Addendum No. 1

RE: Contract ID C203468

WBS # 3CR.10311.147 Etc.

3 Sections of US-117, 1 Section Of US-701, 1 Section Of NC-24 And
NC-50 and 15 Sections of Secondary Road

STATE	STATE PROJECT REFERENCE NO.	SHEET NO.	TOTAL SHEETS
N.C.	3CR.10821.147	2	
STATE PROJ. NO.	F.A. PROJ. NO.	DESCRIPTION

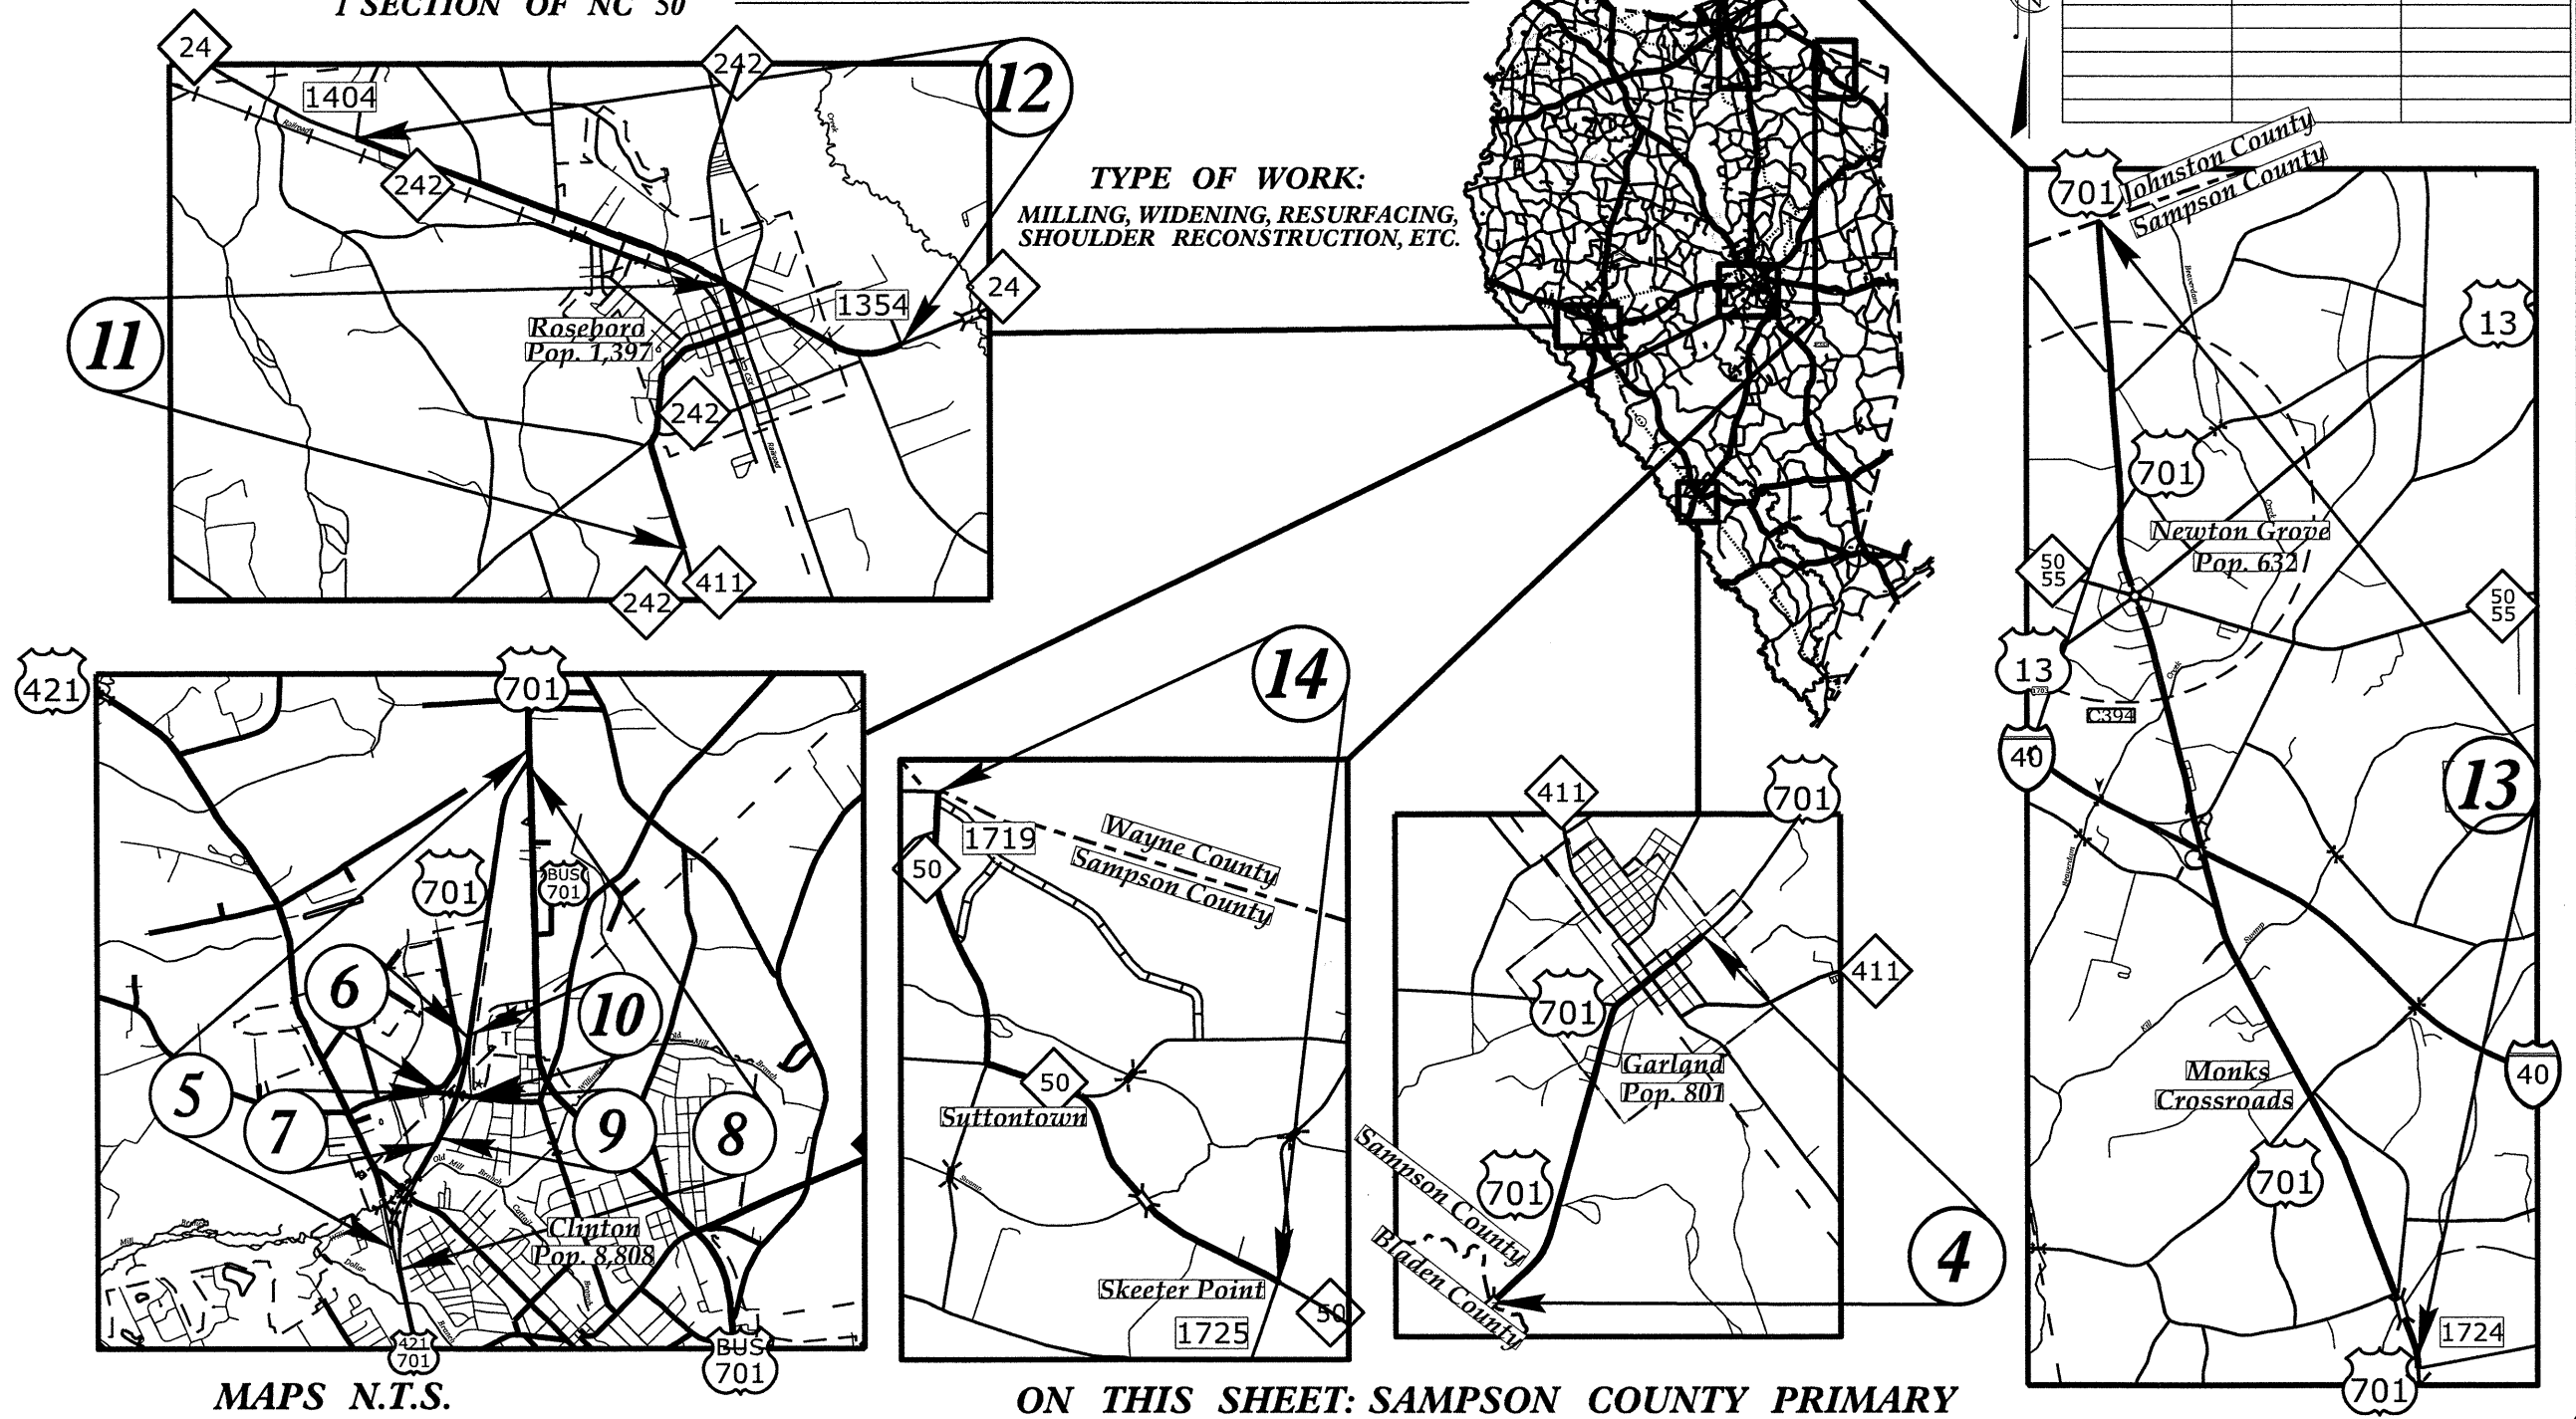
Sheet No. 2 has been revised to show the correct location of Maps No. 5 thru 10. Please void Sheet No. 2 in your plans and staple the revised Sheet No. 2 thereto.
